East Suffolk Communities Energy Partnership (ESCEP)

National Grid Electricity Transmission – Sealink – EN020026

Deadline 3A Written Representation (WR)

3. This representation by ESCEP relates to Change Request 1 and specifically to Change 4 Benhall Railway Bridge, Suffolk which forms part of the Applicant's Change Request as set out in its cover letter of 26 November 2025 (Library Reference CR1-001).

nationalgrid			
Application Number: EN020026			
National Grid Drawing Reference: CHANGEAPP/S/LRP/S/0117			
Scale: 1:2,500	Sheet Size: A0	Sheet: SHEET 7 OF 7	Issue: C ver 2

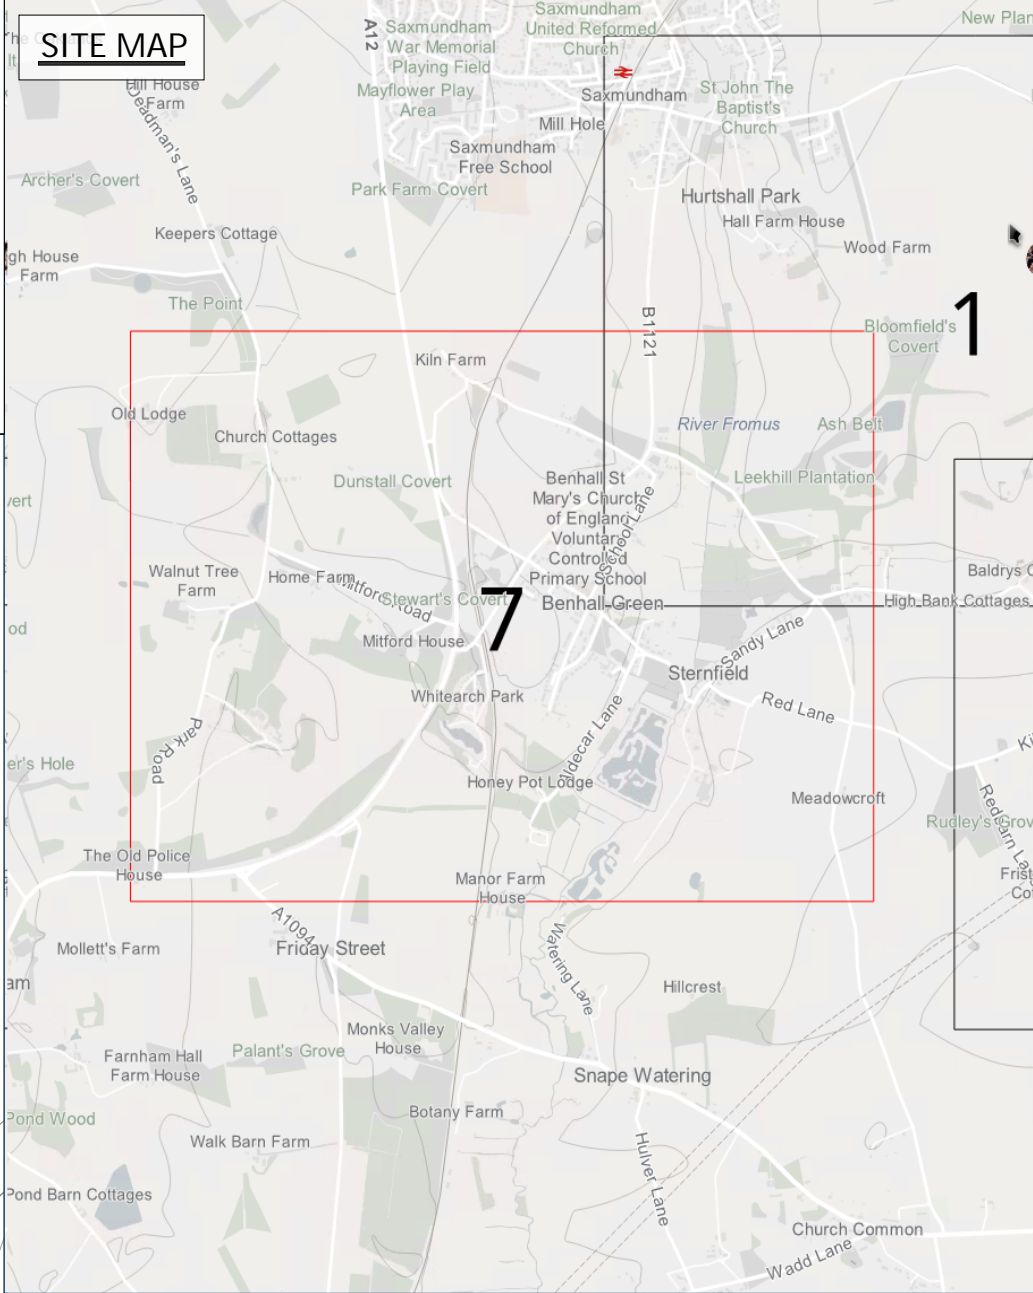
5. The land shown in the Applicant's document 2.3 (C) Land Plans Part 1 of 2 Summary of Changes (Version 2, change request) (Library Reference CR1-004) on drawing reference CHANGEAPP/S/LRP/S/0117 does not include the land where temporarily use is required to access plots 7/21 and 7/26. ESCEP believe it is not the intention of the Applicant to crane, or otherwise lift down and up, plant and personnel to those plots from the B1121 highway to undertake the tasks detailed in CR1-052. The Change Request details are thus incomplete.

14. As a load competent 'mini bridge' has not been found in a search by ESCEP it is unclear to ESCEP if such a competent 'mini bridge' exists that the change plan limits are adequate to install and remove the bridge for each AIL passage without encroaching on or oversailing adjacent land.
